COMMENTS ON APPELLANT'S STATEMENT

Planning Inspectorate Reference:	6011996
LPA Application Reference:	3/2025/0823

Proposed conversion of vacant care home (Use Class C2) 622 sq.m. into two semi-detached residential 5 bed dwellinghouses; Use of two storey annex as incidental accommodation; erection of two storey rear extension to one dwelling and erection of single storey side and rear extension to one dwelling together with dormers to front and rear elevation, first floor balconies to rear elevation, portico to front elevation, changes in fenestration and introduction of additional doors and windows to both properties and associated parking and landscaping.

Longworth House, Higher Ramsgreave Road, Ramsgreave BB1 9DJ

DRAWING TITLE :
 PROPOSED ELEVATIONS

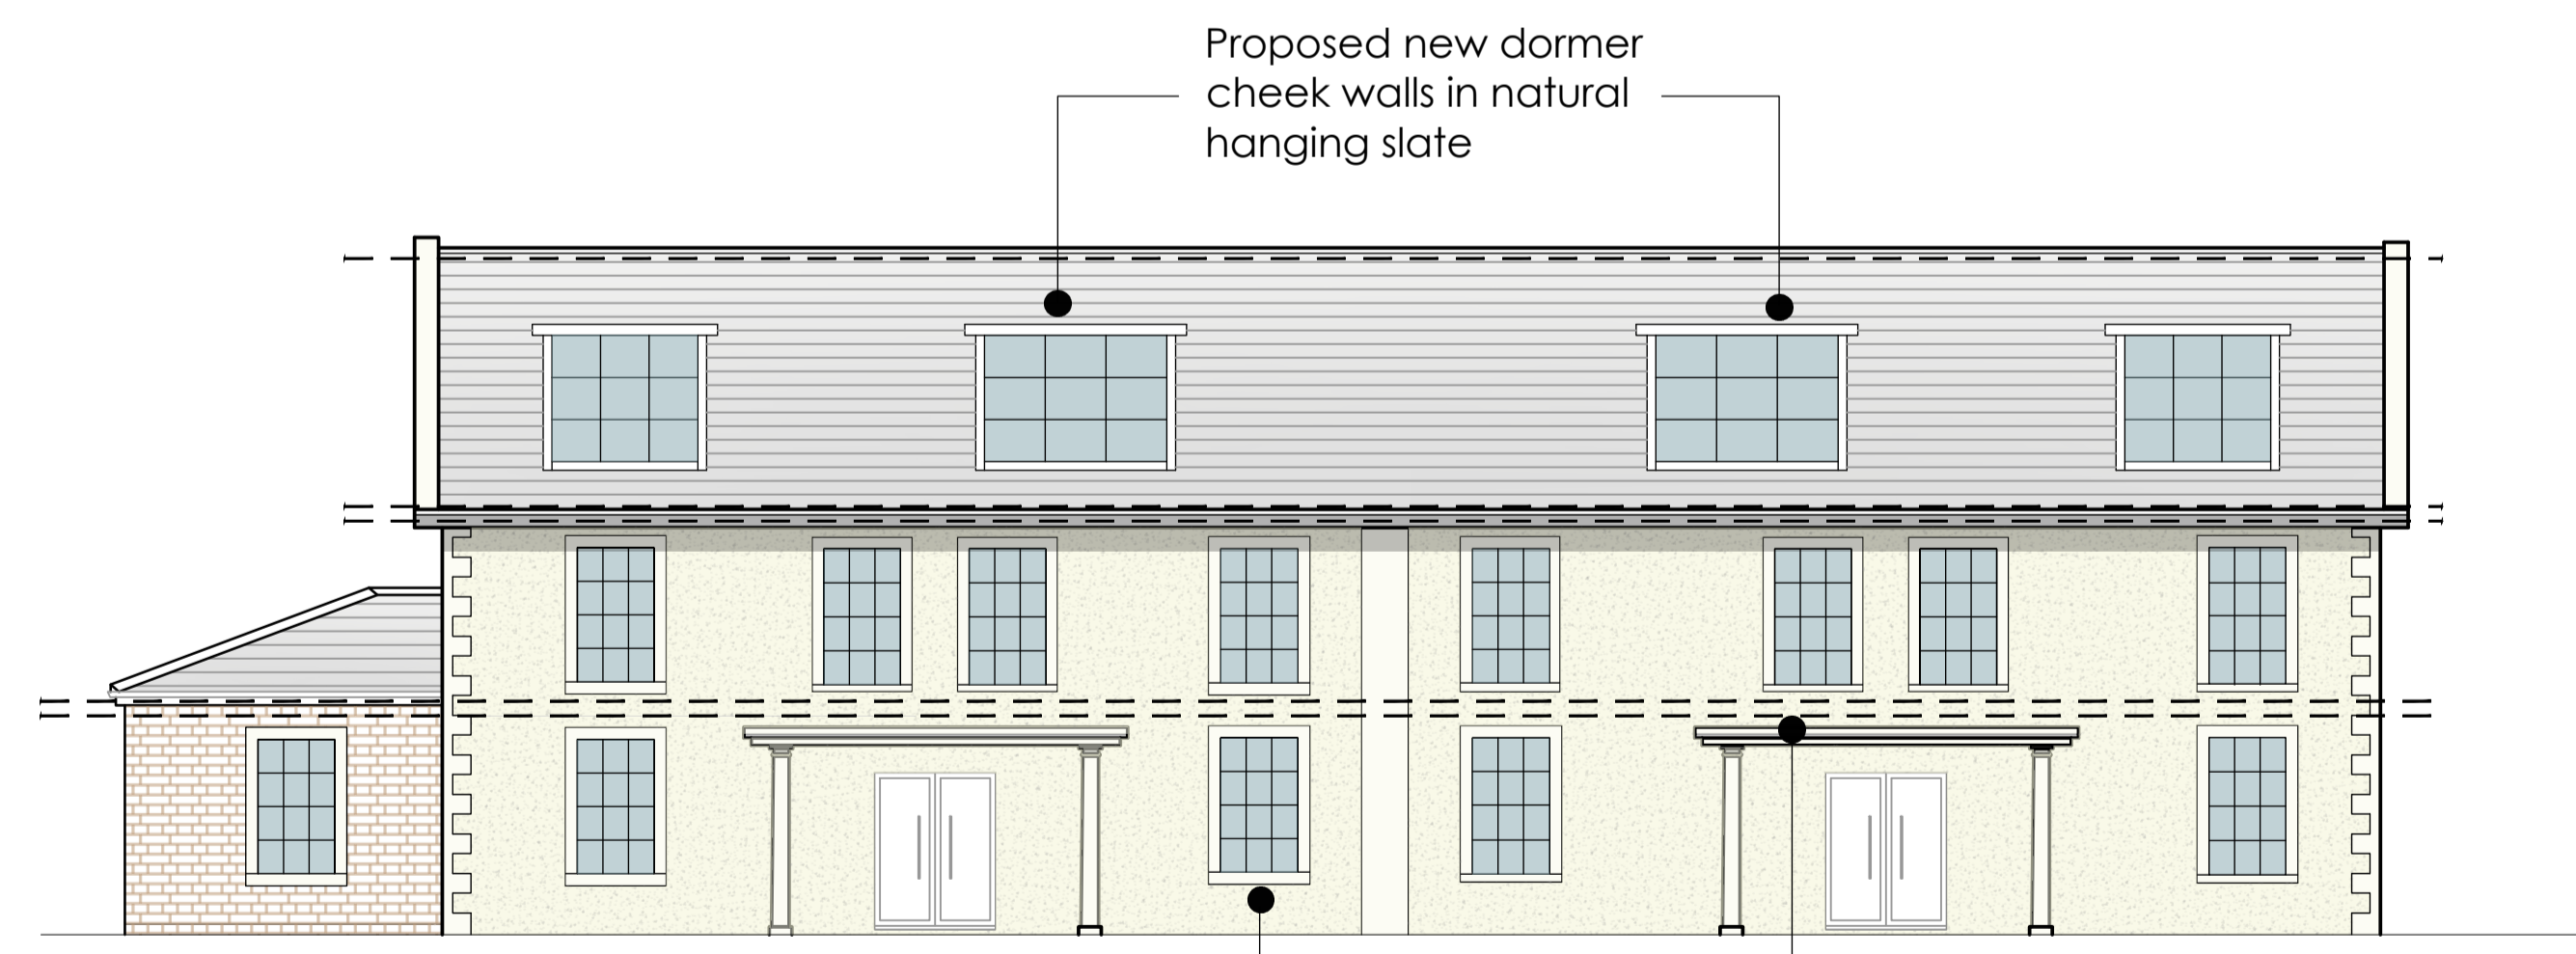
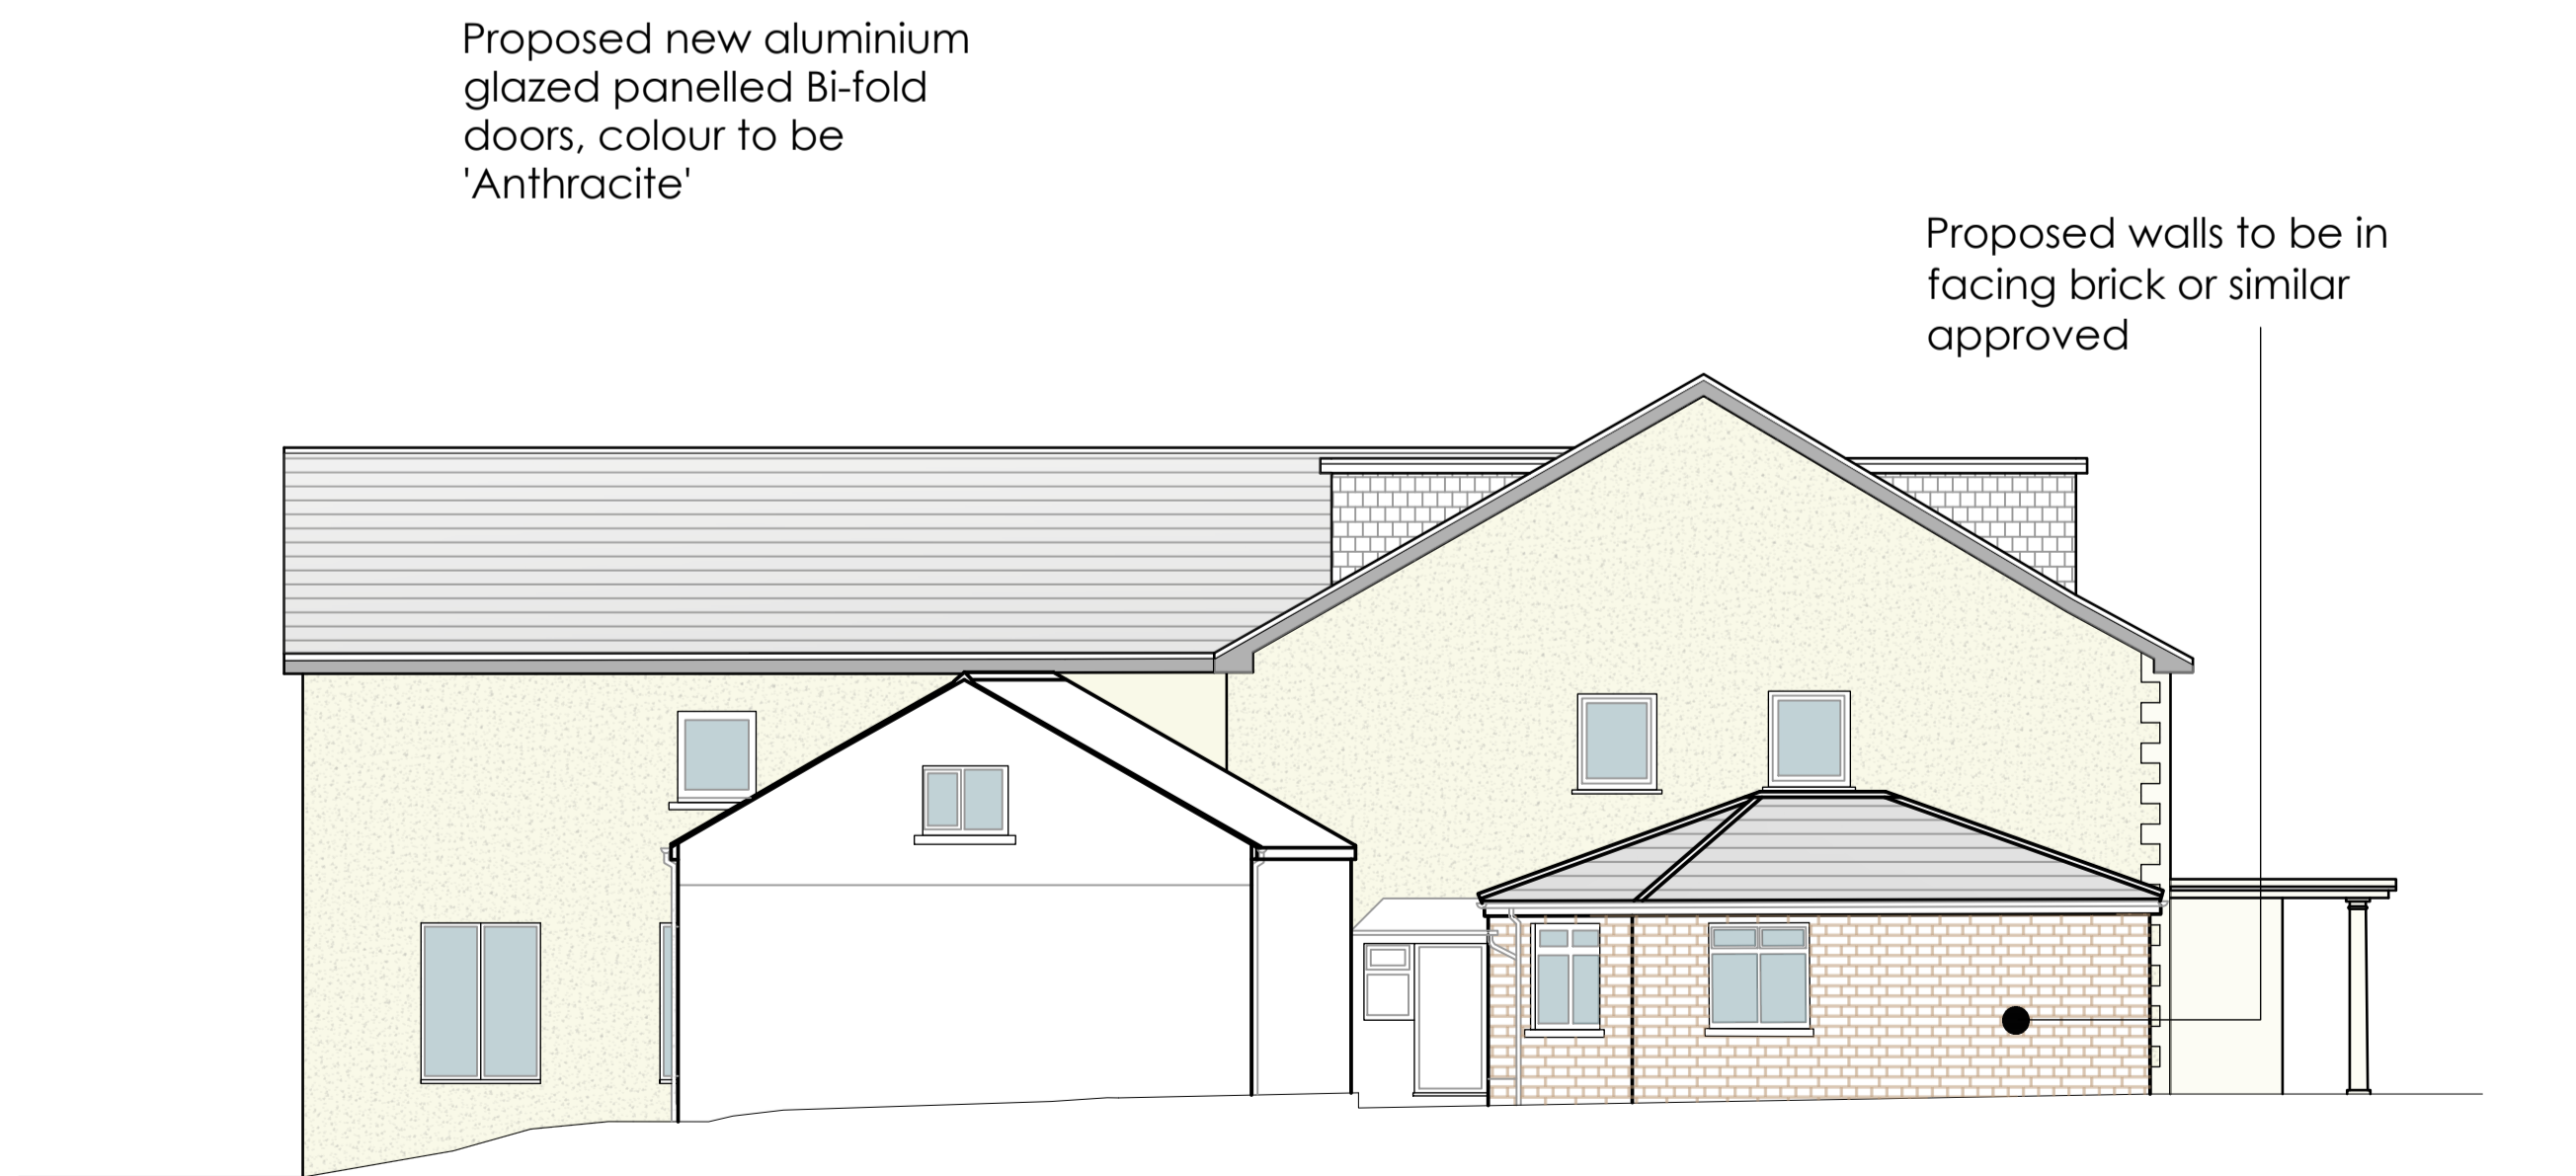
- 1.4 The appellant at 3.12 claims that the front and rear dormers would be “simple and elegant” with the flat roof design minimise their mass and unobtrusive. The LPA is of the view that a total of six dormers on both the front and rear elevations add to the overall bulk and scale of the proposal, which has public views from the existing public footpath which runs through the site (point 1.2 above).

- 1.6 The appellant referred at 3.24 to the existing porch and its replacement with two front porticos and that the portico's would mark the new front entrances to the two dwellinghouses. These features, together with the proposed extensions and dormers add further to bulk of the building whereas the existing porch retains a more domestic scale of development.

- 1.1 The appellant has stated at 3 that the two storey extension would square of the ground floor and continue the ridge line it would not appear “bulky” and would “add minor additional volume”, however, the LPA does not consider this to be case as the property is already substantial and has been added to considerably since it was last in use as a dwelling.

DRAWING TITLE :
 PROPOSED FLOOR PLANS

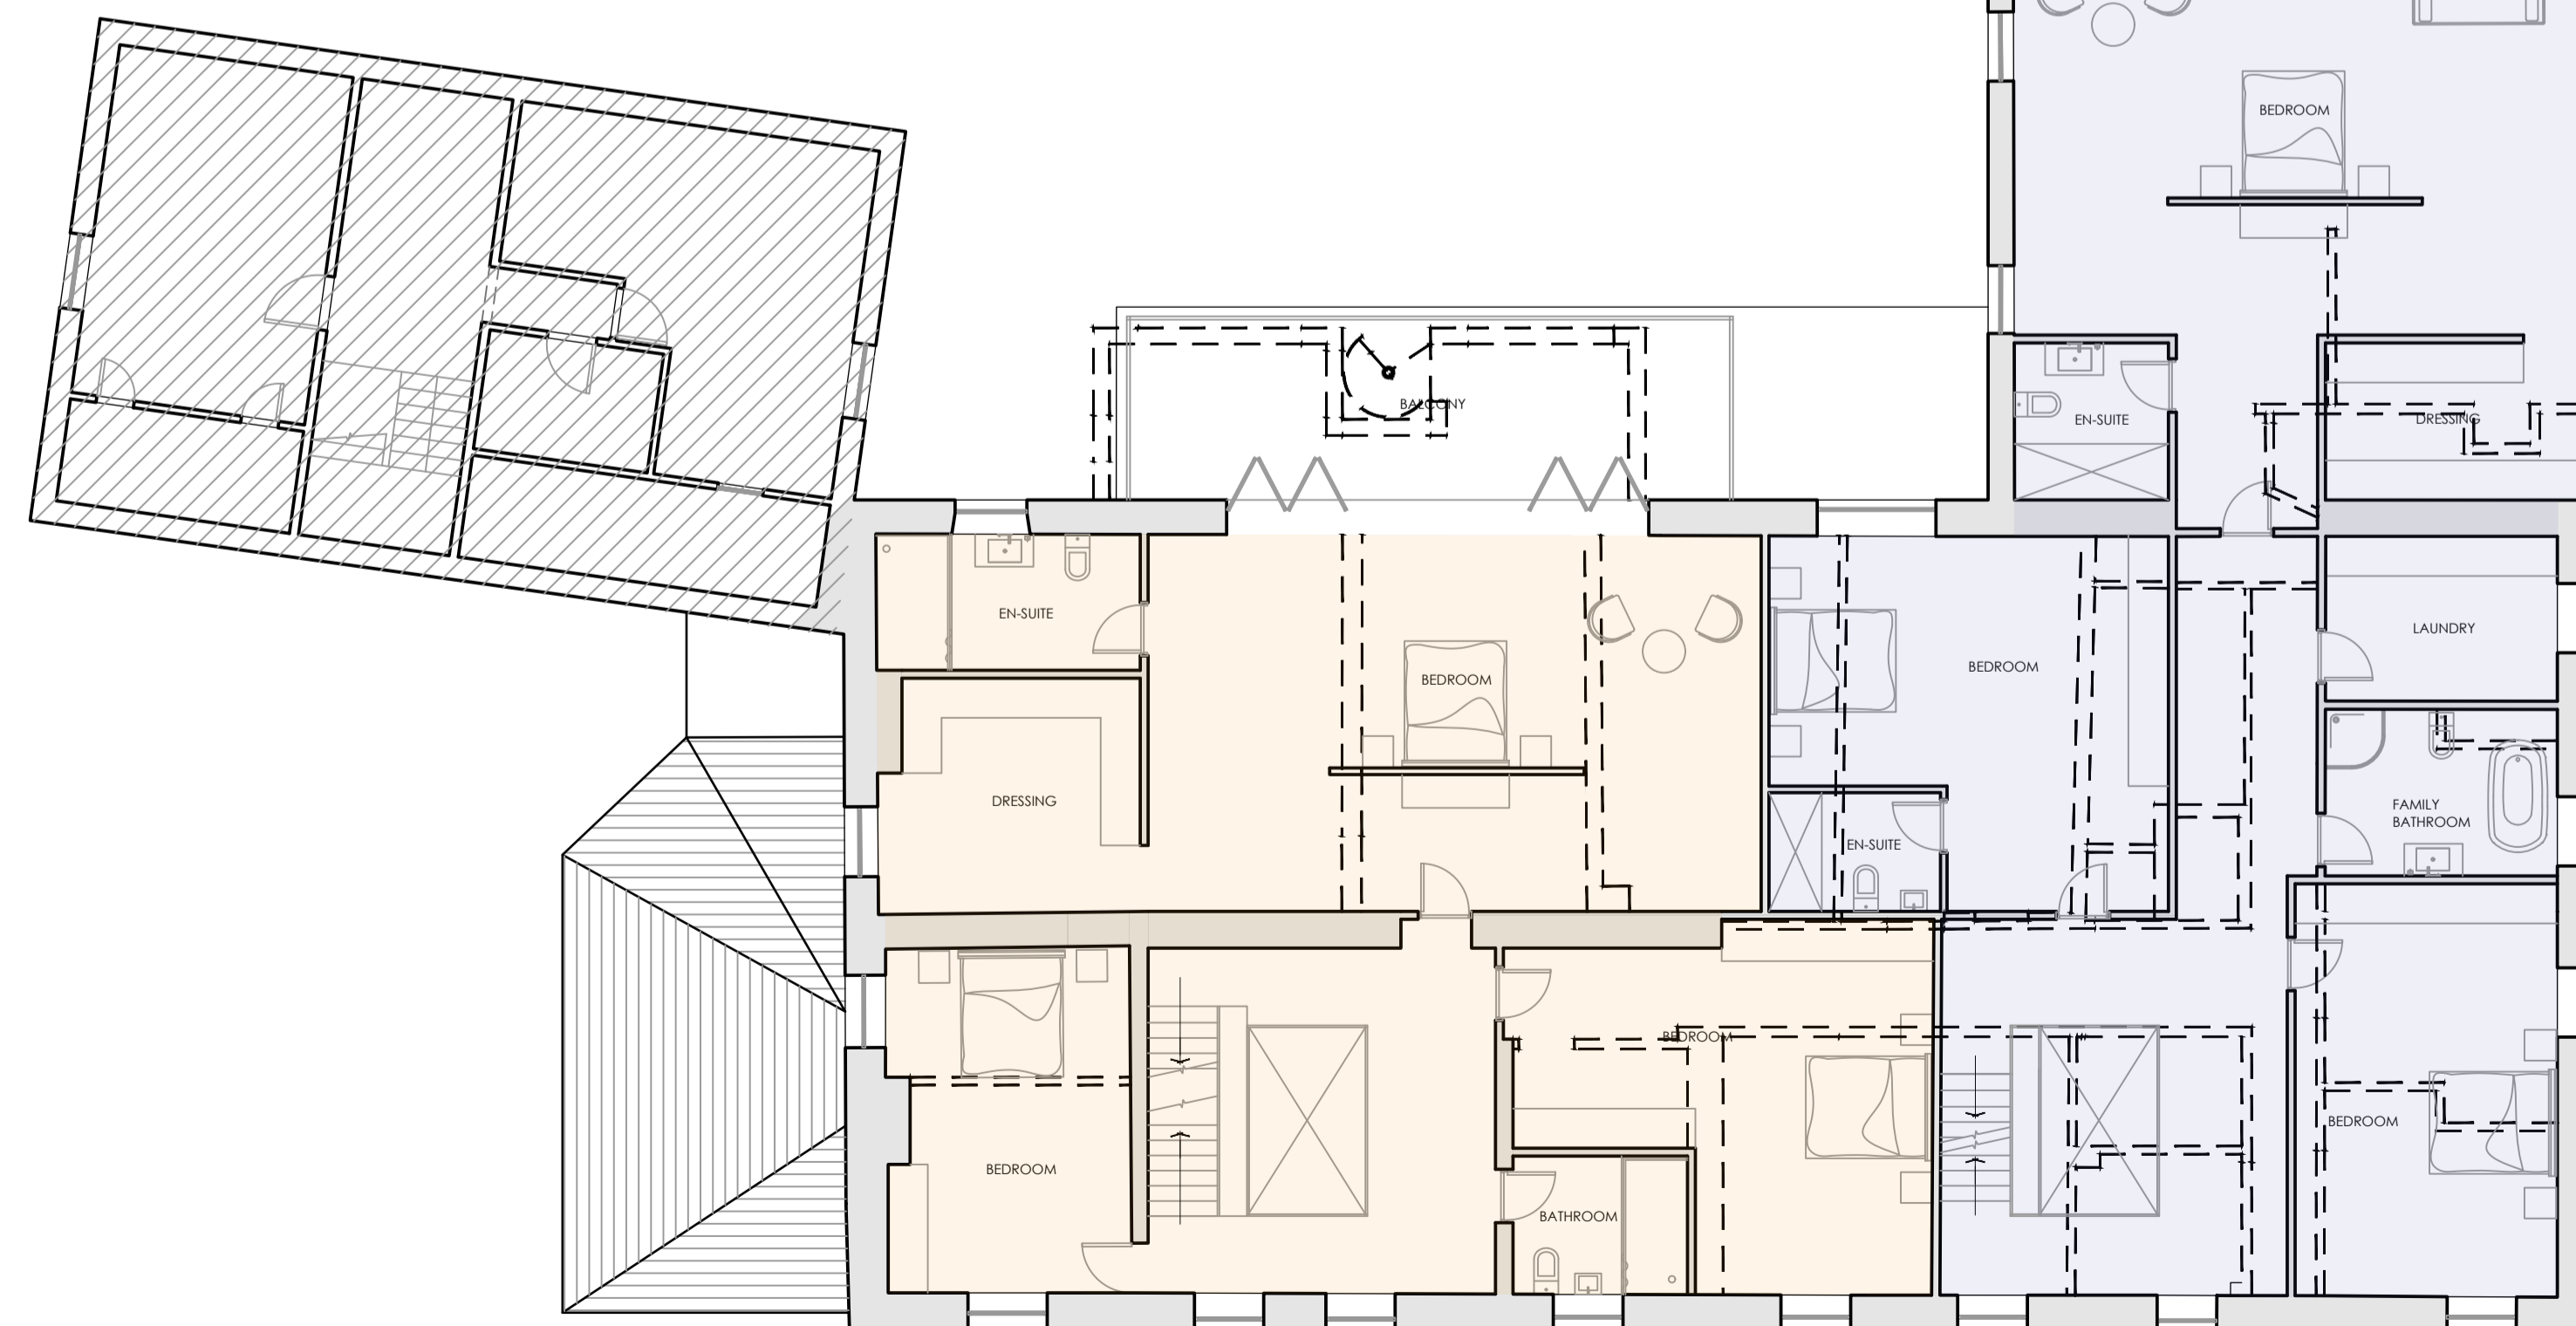
- 1.5 The appellant suggests at 3.19 that the presence of an existing balcony together with a fire escape on the rear elevation of the care home allows for a new balcony to be erected above a single storey projection which would not extend out further than the fire escape. However, this balcony would provide views into the first floor windows on the western gable projection of the adjoining eastern dwellinghouse which serves a bedroom thus raising concerns over privacy and overlooking. There would also be loss of privacy and overlooking from the eastern dwellinghouse from these same gable bedrooms windows into the bedroom of the western property to which the balcony serves with its large bi-folding window openings.
